**Consultation Response from KC,
Trees**
2021/92667 99, New North Road, Edgerton, Huddersfield, HD1 5QL
Erection of retaining wall, gate pillars and gate, alteration of existing access and new surface to drive (within a Conservation Area)
Date Responded: 05/11/21 Responding Officer: NG Responding Ref:CA32

| DRAWING No.<br>TF5/Area A/AW/99NNR-1B                                      |             |          |

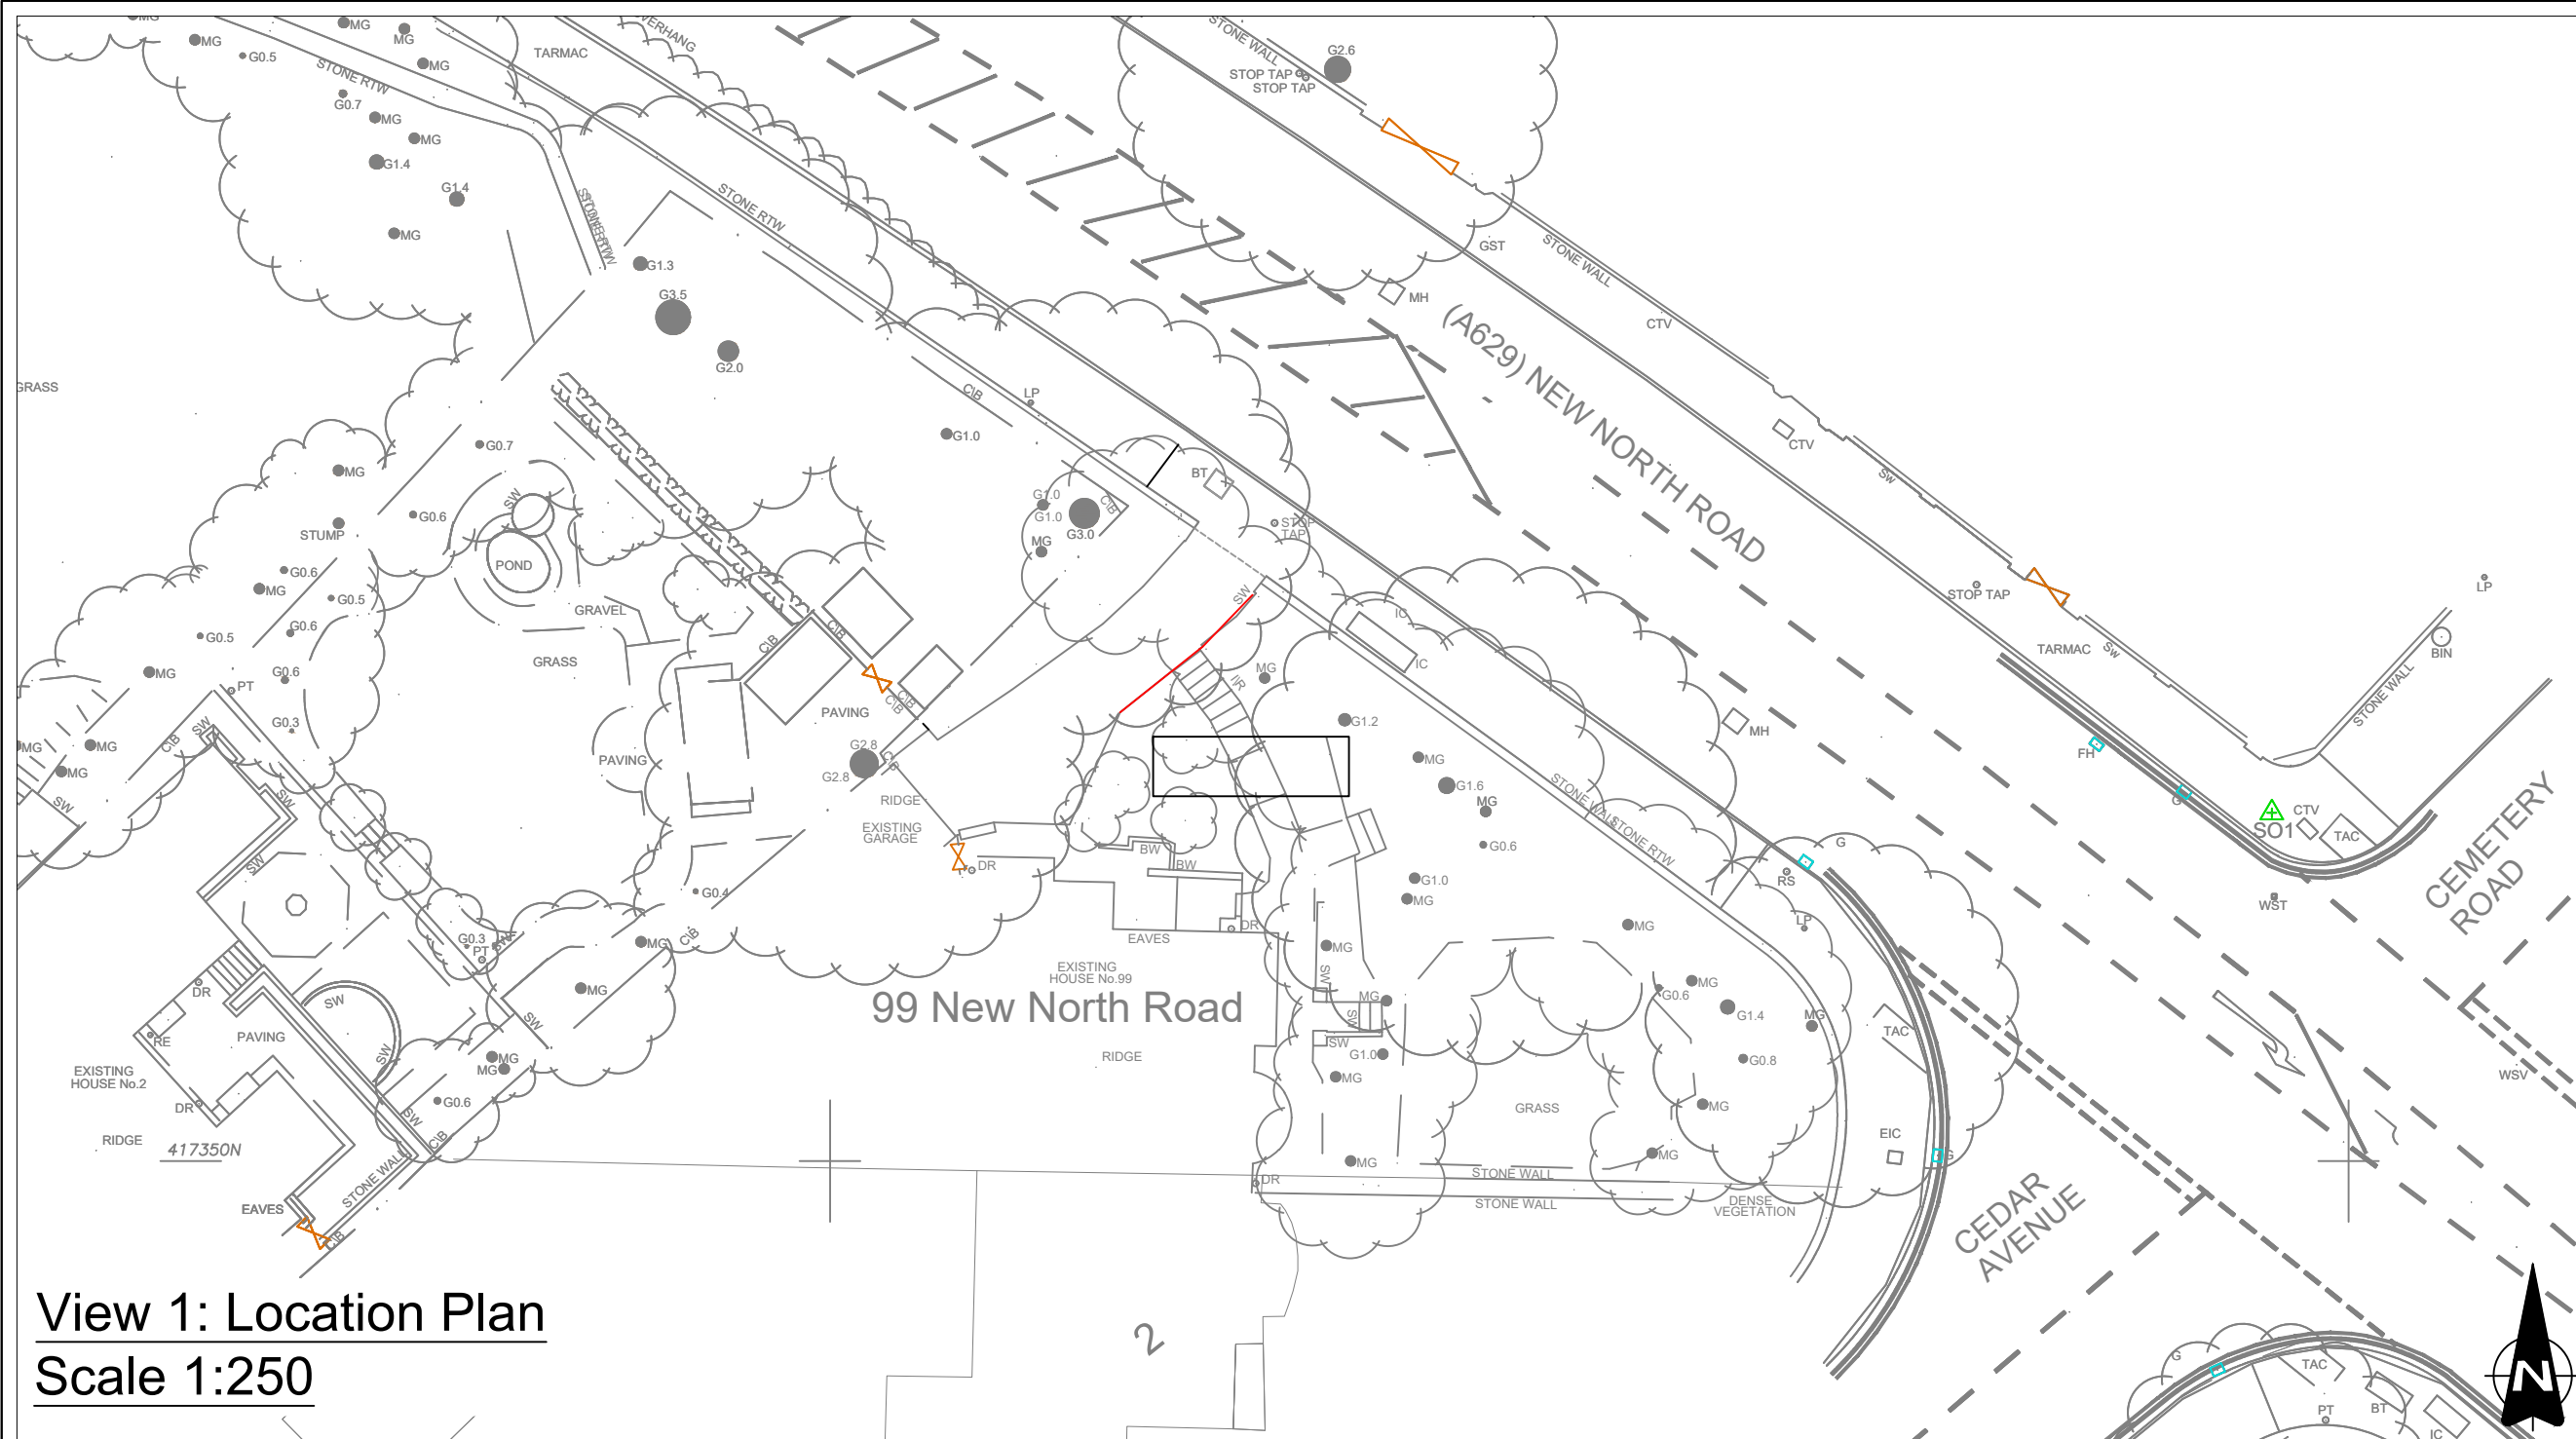
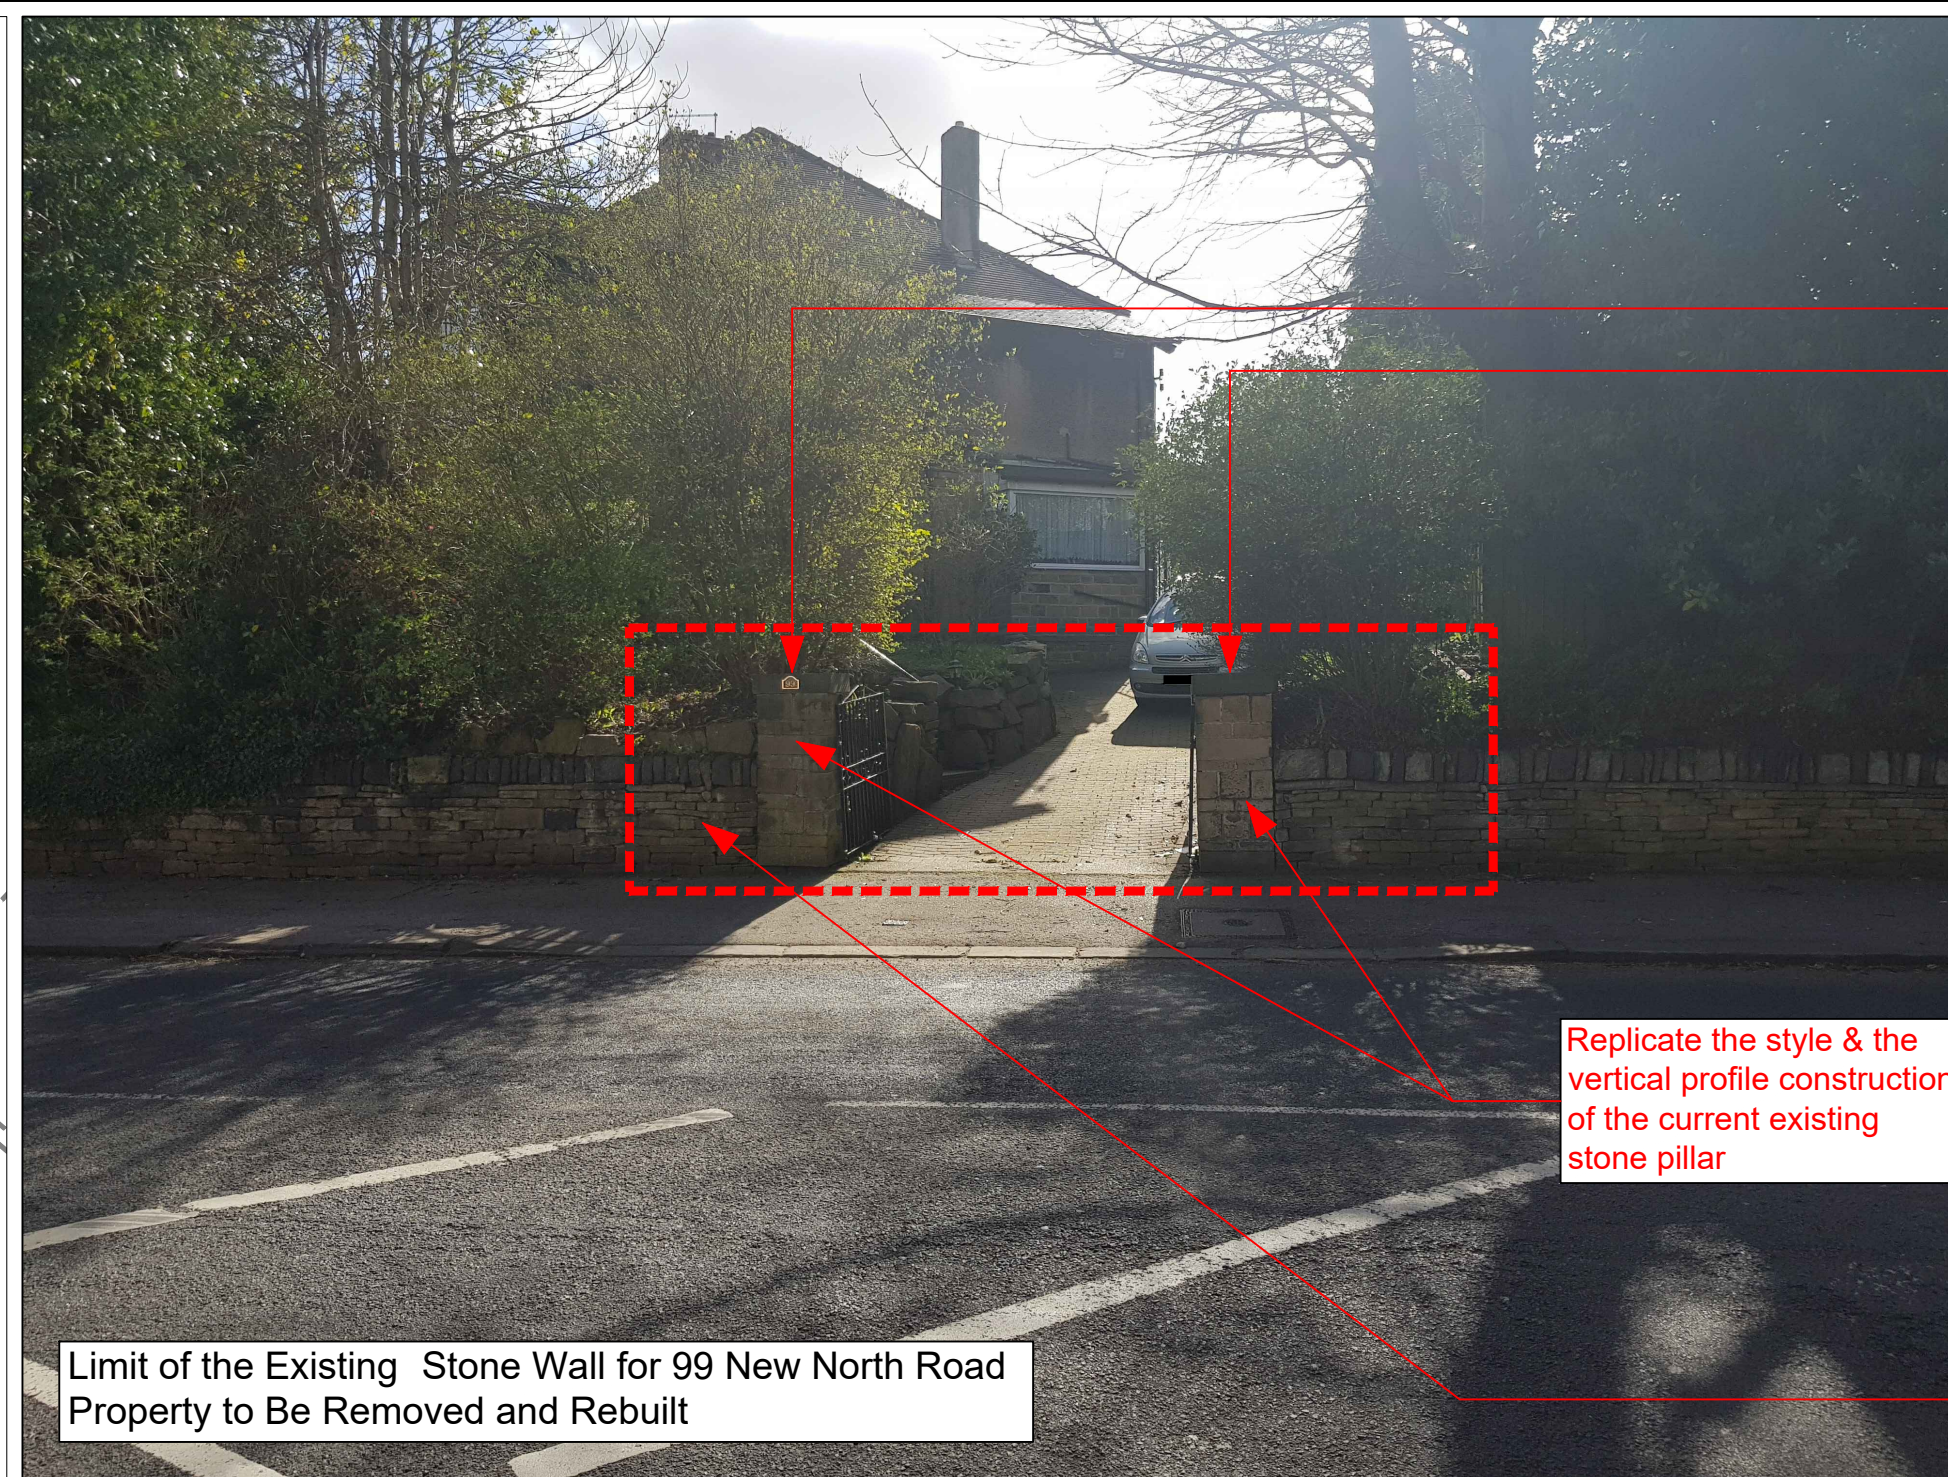
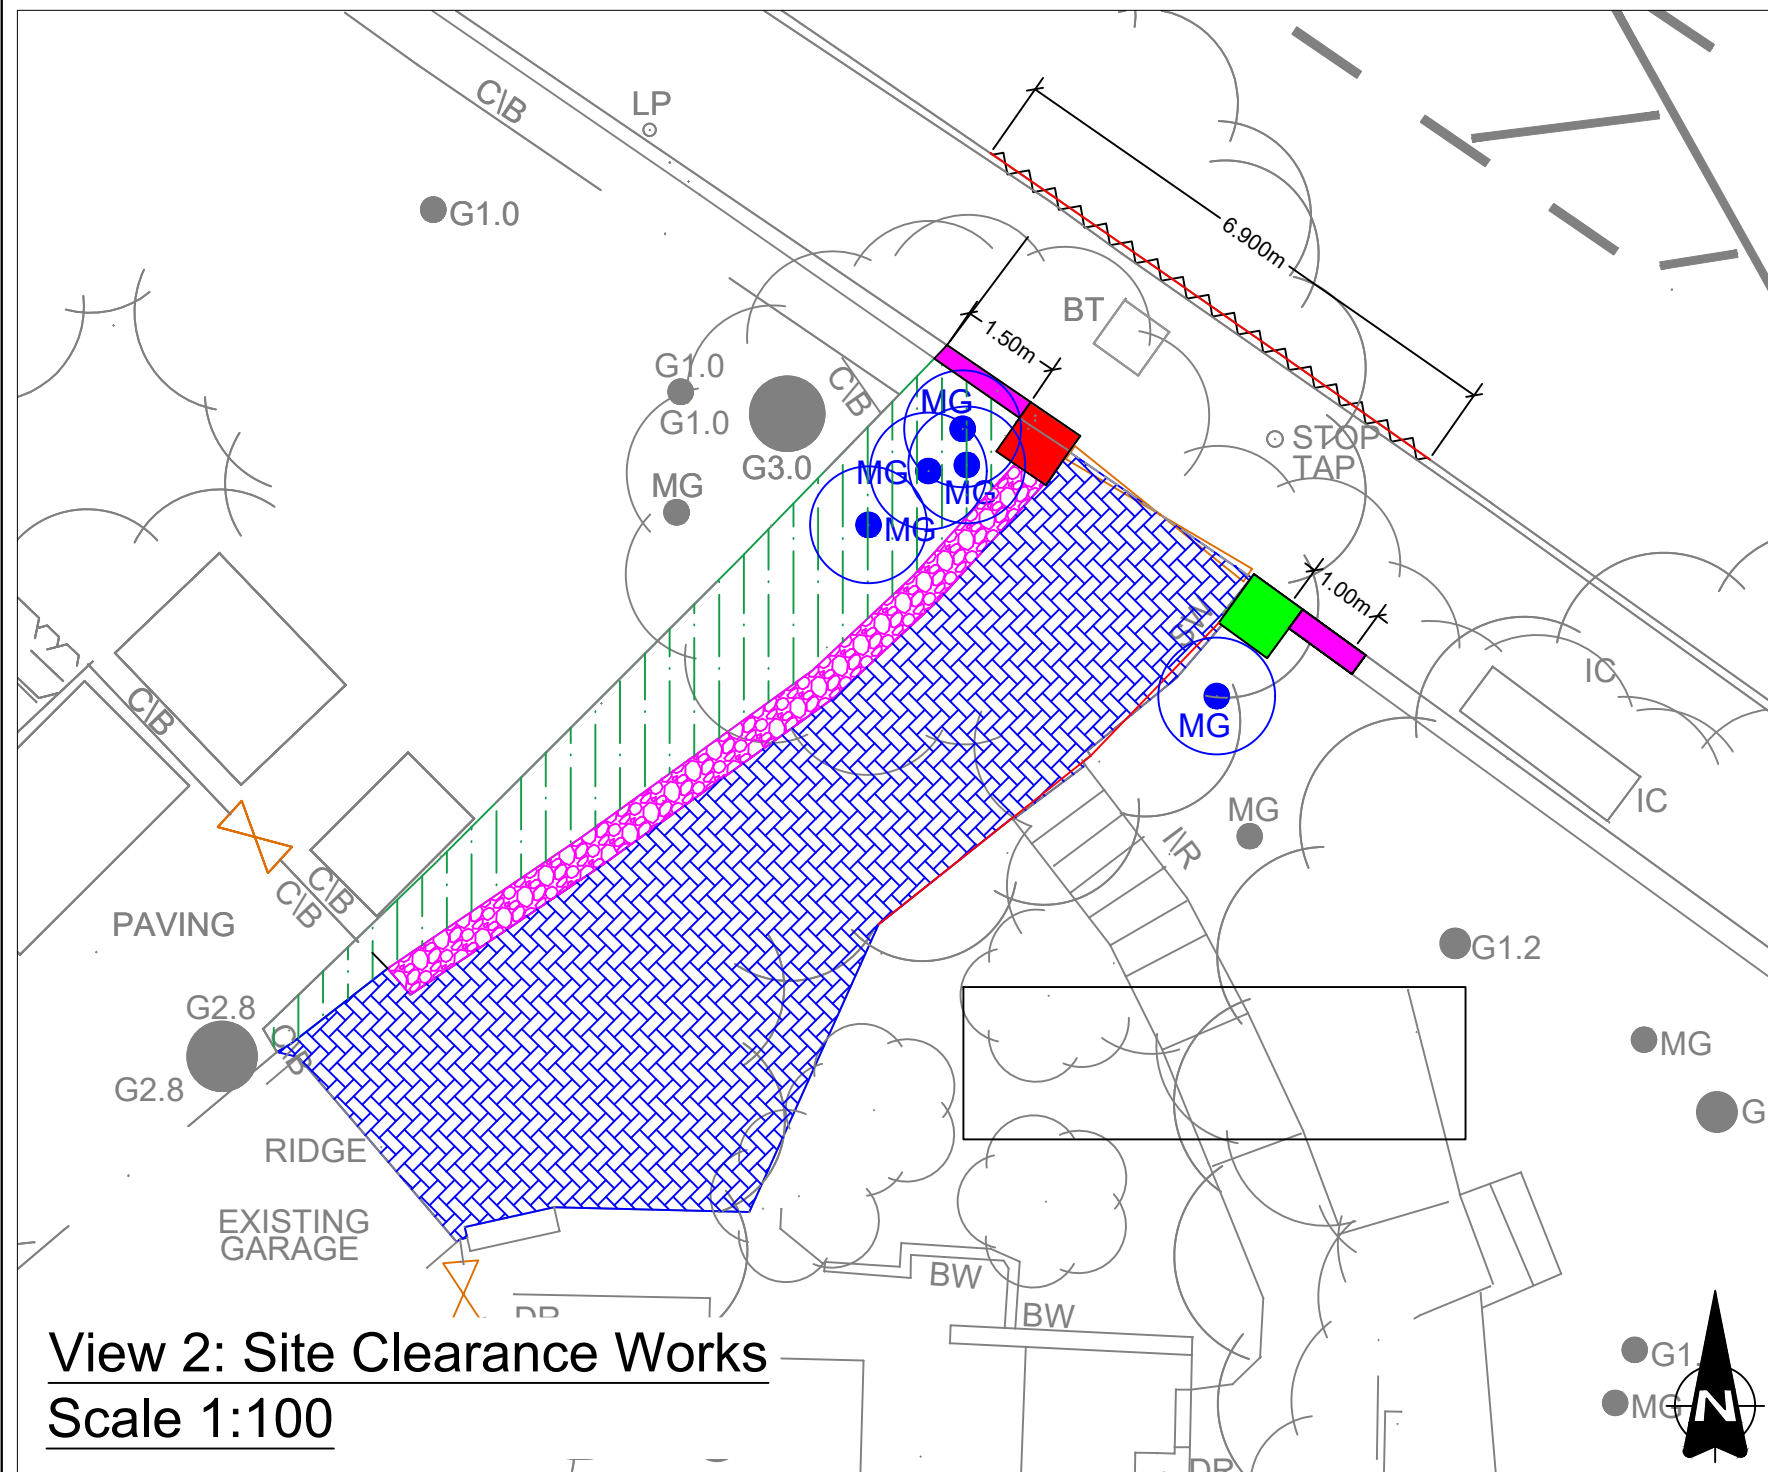
The application form does not acknowledge the trees adjacent to the site which may be affected by the proposals despite the plans showing two large tree stems of mature trees just offsite adjacent to the area to be excavated.

The proposals to widen the driveway and entrance gateway requires a significant change of ground level within the rooting area of two significant mature trees within the Edgerton Conservation Area. The proposals are likely to have a negative impact on the long term health and potentially the stability of these trees. The two trees offsite are proposed for removal as part of the application, ref 2021/92734, to widen and improve the A629.

Any consent granted under this application should be linked via condition to the A629 scheme, if possible. If that scheme does not go ahead then the work proposed in this scheme would result in the harm outlined above to offsite trees with significant public amenity which should be avoided.
